CITY OF ALBUQUERQUE

**Re: American Toyota
Drainage Report with Engineer's Stamp dated 12-2-14
Grading and Drainage Plan with Engineer's Stamp Dated 12-2-14
(C18D012)**

Based upon the information provided in your submittal received December 2, 2014, the above referenced plan is not approved for Site Development Plan for Building Permit action until the following comments are addressed:

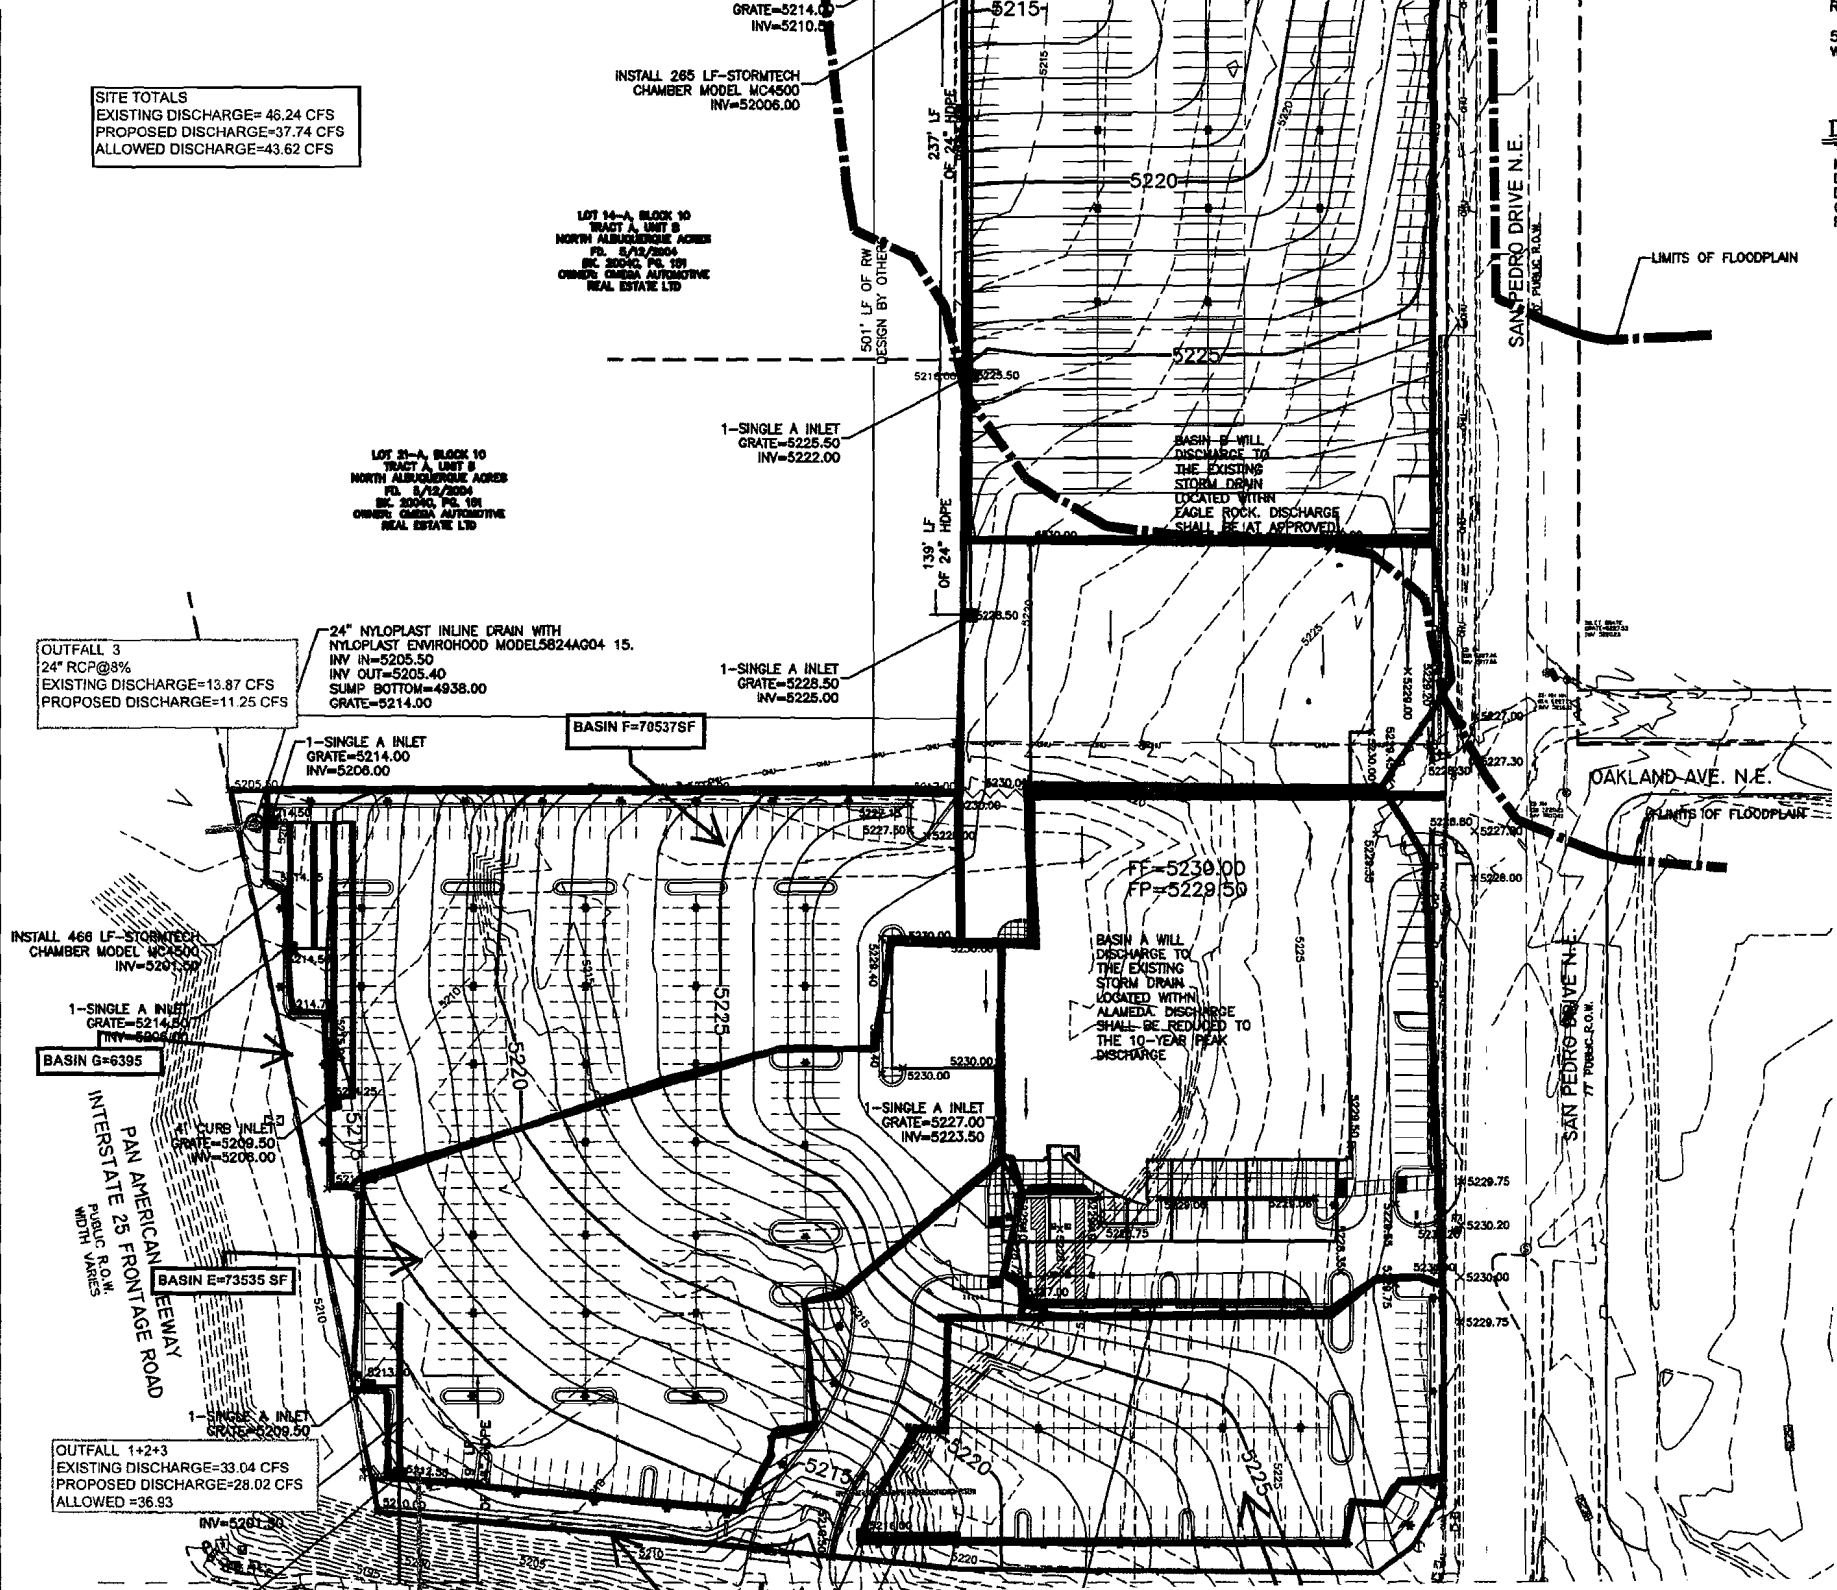
3. What are the flows identified in the DMP for this site?
4. Indicate on the existing basin map where the existing discharges are, the flow, and the pipe size.

5. On the proposed basin map, show the allowable and proposed area, flow, and volume for each basin. For each StormTech system, show the flow and volume in and the flow and volume out. Show the proposed flow and volume being discharged offsite. Show the allowable flow and volume at each discharge location. Indicate the discharge pipe size. Remove notes for editing the drawing. Also delineate Alameda East, Alameda West, Alameda via Frontage, and Eagle Rock Basins. Place the pointer for Basin G in Basin G.

ENGINEER'S SEAL	AMERICAN TOYOTA	DRAWN BY WCWJ
 12/2/14	GRADING AND DRAINAGE PLAN	DATE 12-02-14
		21403-LAYOUT-1-25-14
	 <i>Rio Grande Engineering</i> 1806 CENTRAL AVENUE SE SUITE 201 ALBUQUERQUE, NM 87106 (505) 872-0999	SHEET # —
DAVID SOULE P.E. #14522		JOB # 21403

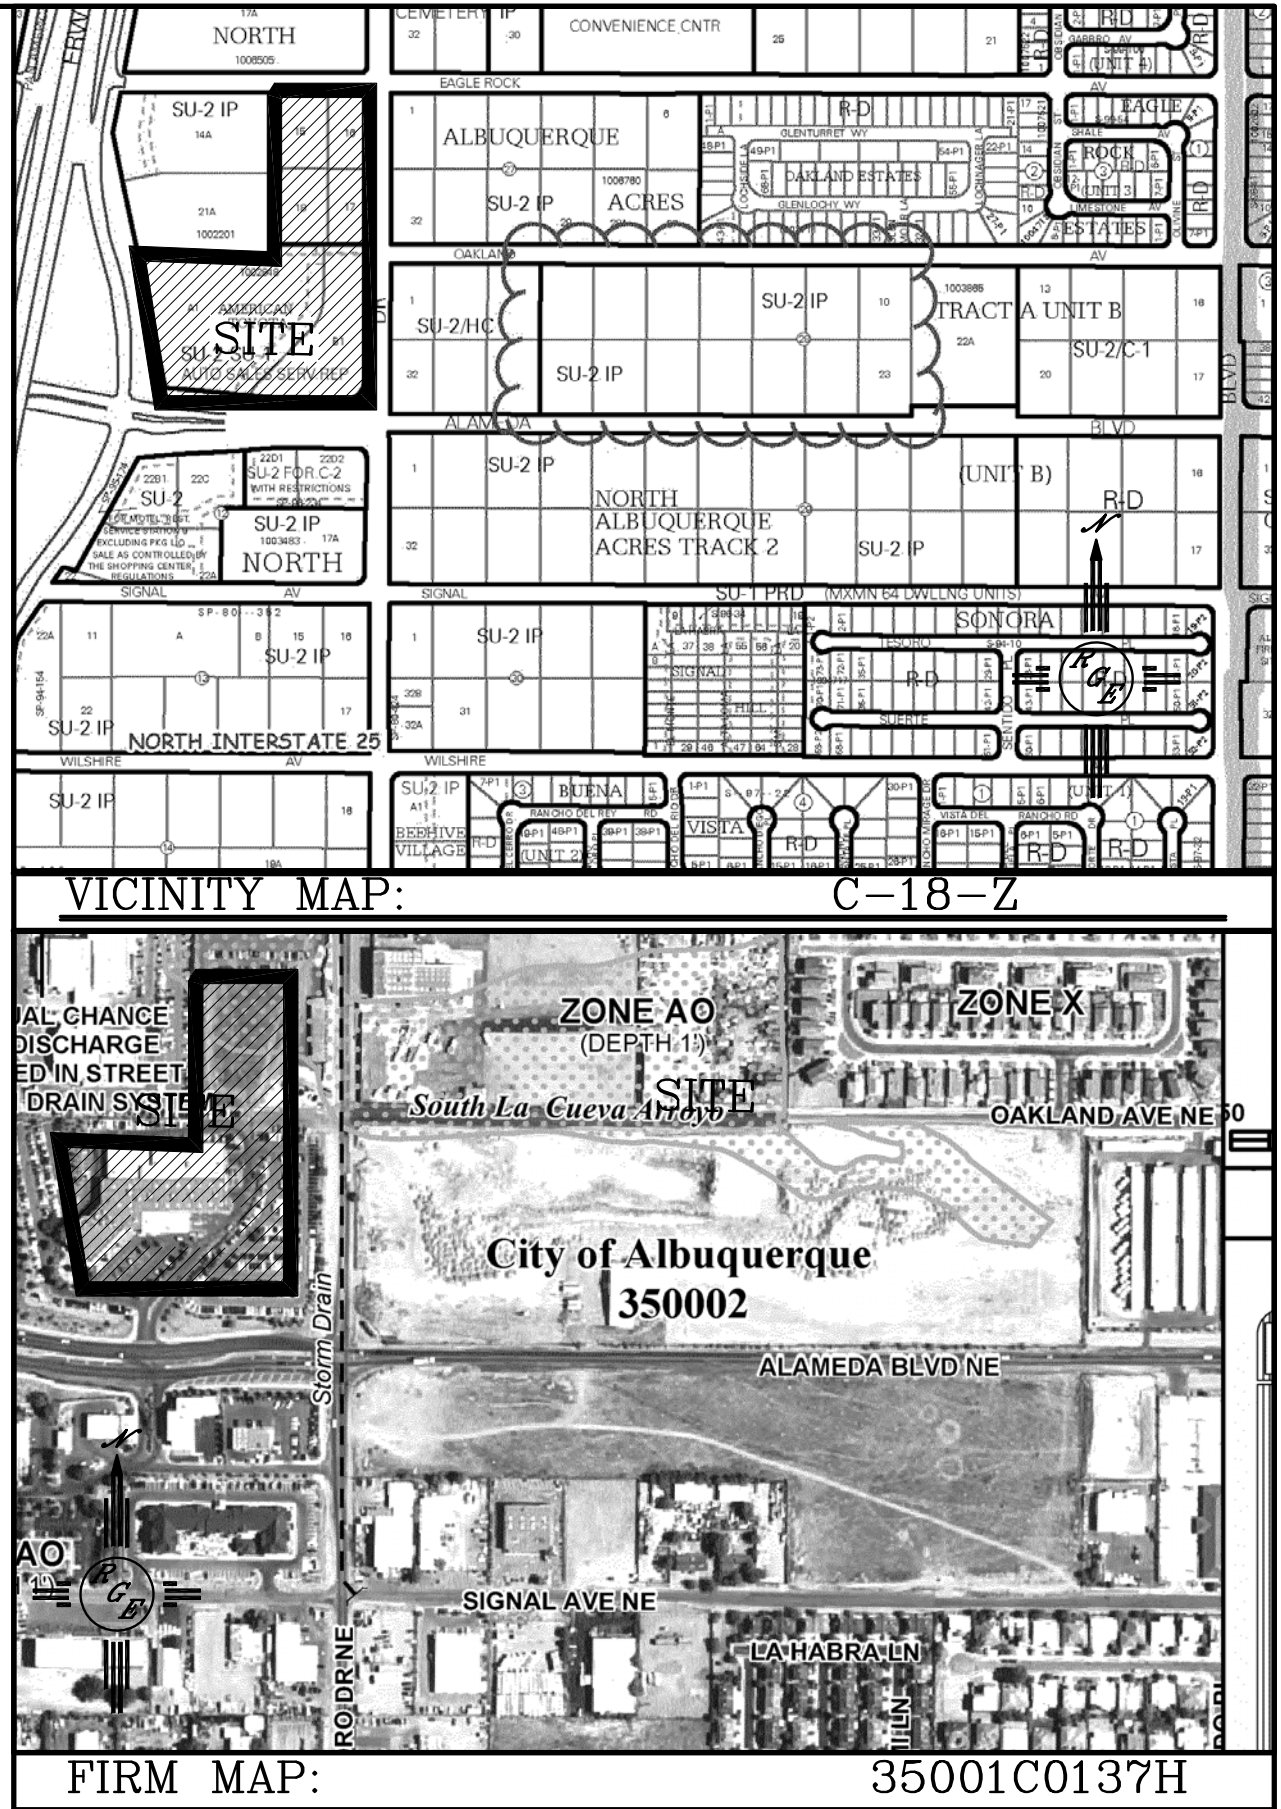
10. In the southwest corner, what is the size and invert of the pipe connecting to the StormTech system?
11. In the southwest corner, show the size of outlet pipe. What is this pipe connecting to? Provide a detail of the inlet showing how flow will go into the StormTech system and into the Alameda system.

12. For the two systems south of the proposed building, how do the excess flows discharge?
13. In the northwest corner, what are the sizes of pipes connecting the systems?

14. For the northern basin, this site will no longer be utilizing the concrete channel west of the northern basin, correct?
15. Is there enough capacity in the Alameda and Eagle Rock systems to accept the flows?
16. Determine the ownership of the Alameda storm drain under I-25. The NMDOT letter that was provided is from 1986. Ownership of various storm drains between the City of Albuquerque and NMDOT has changed since then.
17. Show more spot elevations for the construction of the wall.
18. Provide an electronic copy of the report as well as the drawing.
